From: Fiona Fitzgerald <Fiona.Fitzgerald@arun.gov.uk>
Sent: 01 June 2022 10:10
To: Planning.Responses <Planning.Responses@arun.gov.uk>
Cc: Maria Tomalova <Maria.Tomalova@arun.gov.uk>
Subject: P/82/22/PL

Please could the applicant confirm whether noise from the unit has been taken into account when siting this unit? Whilst I note that the acoustic data has been provided in the manufacturers specifications, I am unsure which way round the unit will be faced, and whether the residential dwellings over the road have been taken into account when siting the unit?

Drawing **PROPOSED SITE/BLOCK PLAN**

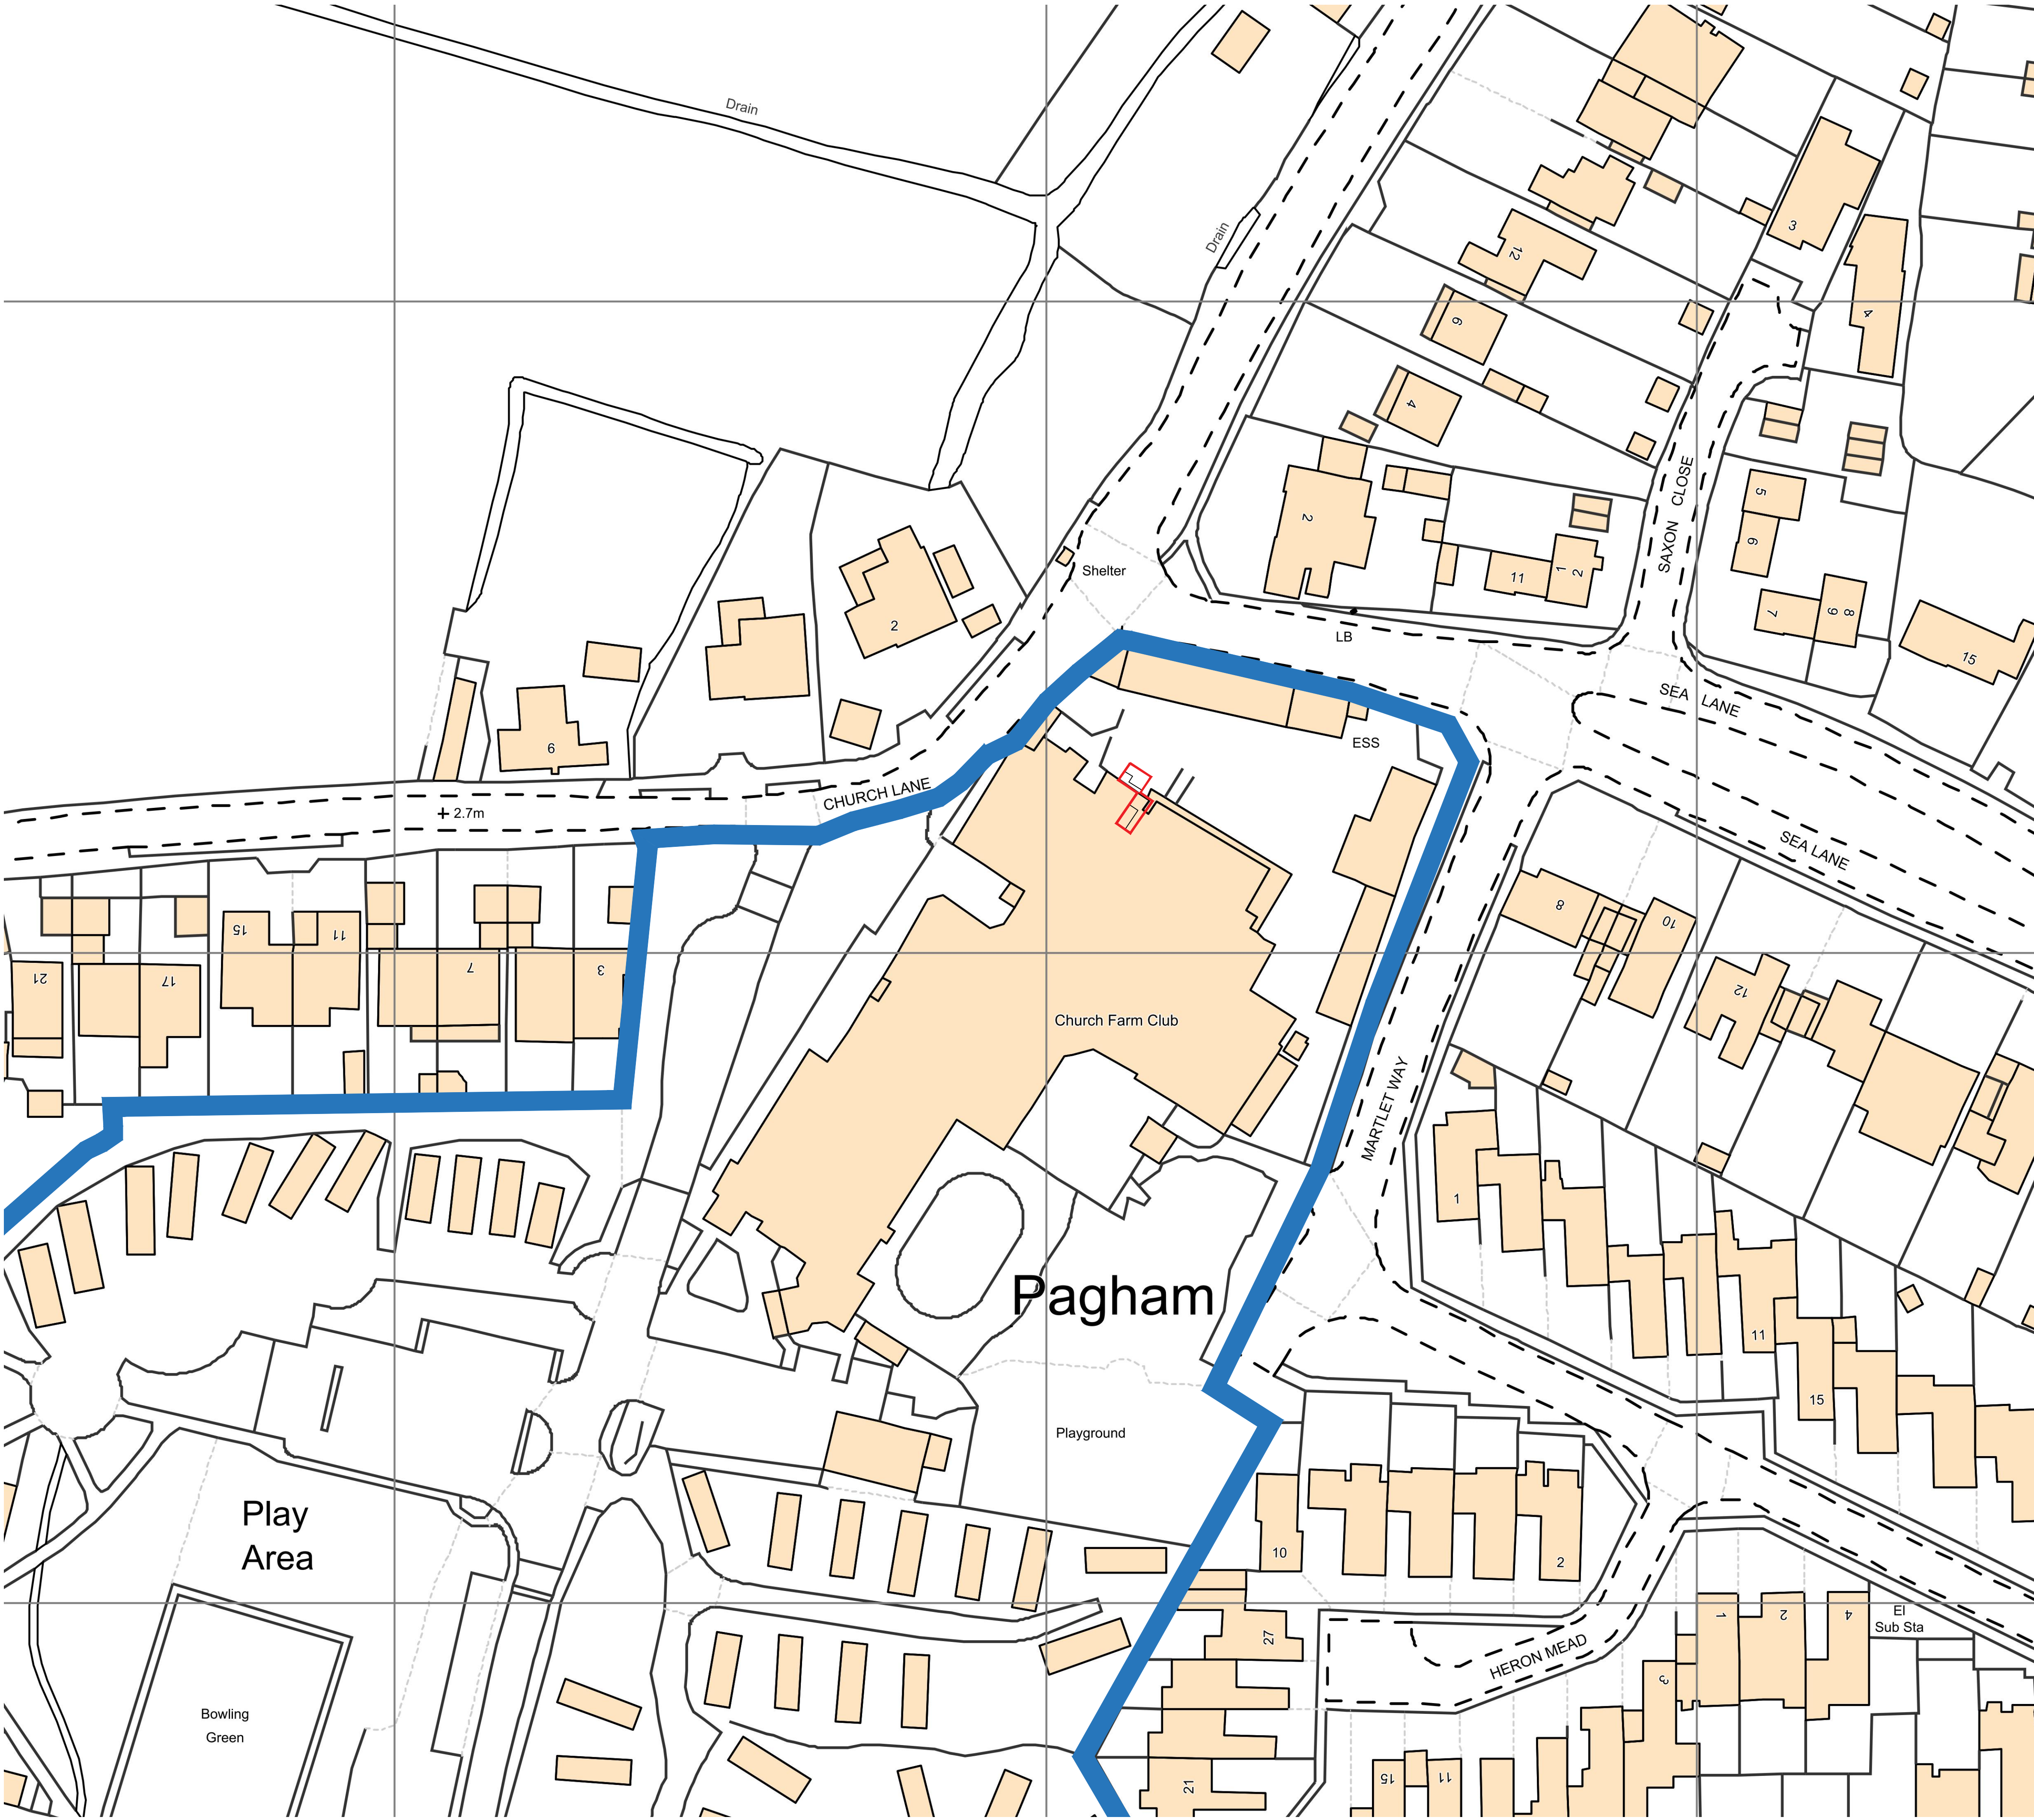
Apologies, I have re-read my original email in relation to this and realised that I have not been clear. Please could the applicant provide a BS 4142 assessment to answer the queries from my last email?
